Subject: HVO North and South Open Cut Coal Continuation Project (SSD-11826681 and SSD-11826621) (Singleton Shire)

Attachment 1 - CPHR Comments

HVO North and South Open Cut Coal Continuation Project

Figure 7 – River Red Gum restoration areas

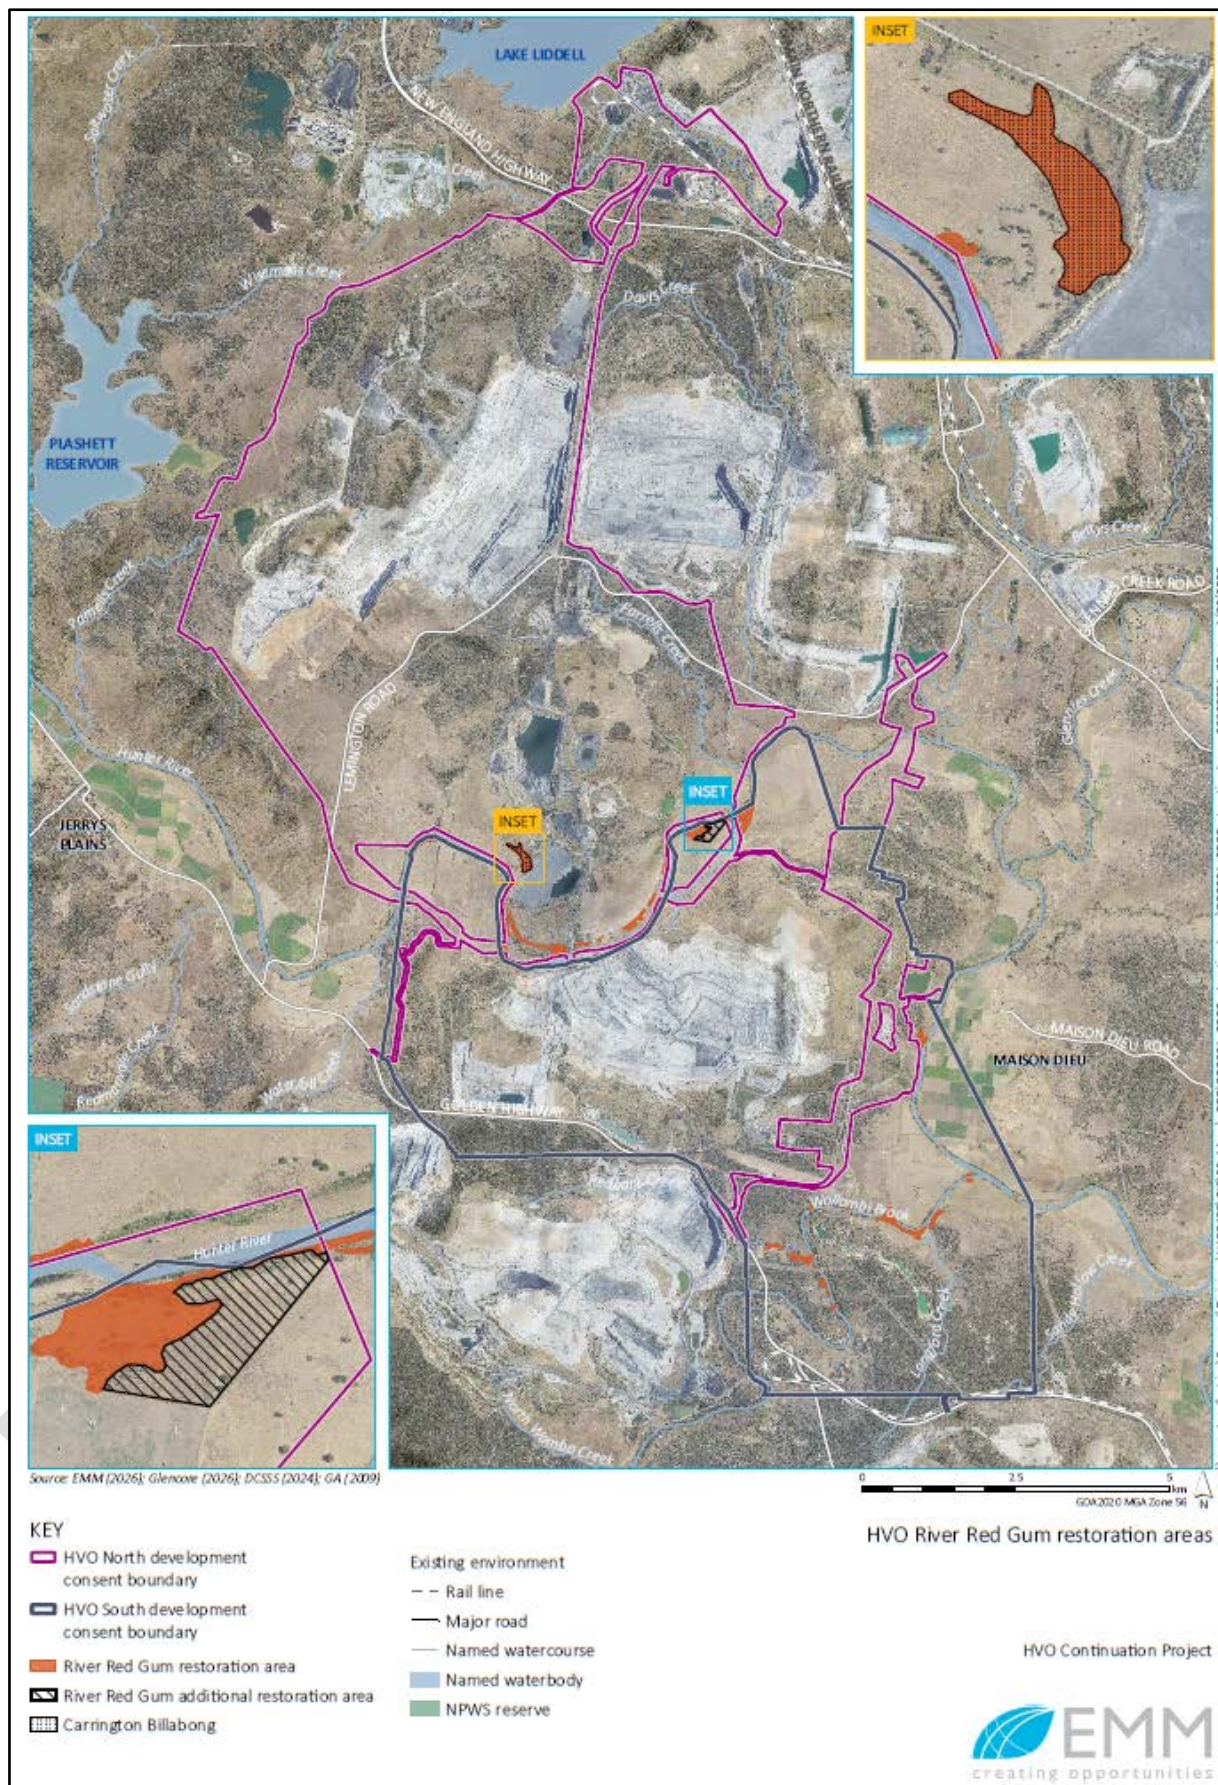
4	<p>CPHR supports the inclusion of 6.6ha of land entering into conservation, however, considers that the current River Red Gum Rehabilitation and Restoration Strategy (RRGRRS) does not reflect best practice management methods that reflect the current onsite conditions.</p> <p>Findings from the recent HVO RRGRRS assessment (HVO, August 2025) indicate that rehabilitation within the existing protected areas has not been demonstrably successful.</p>	<p>CPHR recommends that any approval include consent conditions requiring the preparation of an updated RRGRRS, to include the additional 6.6ha and provide improvements to the plan to ensure that positive and measurable environmental outcomes can be achieved.</p> <p>CPHR requests that the revised RRGRRS be developed in consultation with, and to the satisfaction of, CPHR to ensure its adequacy.</p>	To be conditioned prior to commencement of works
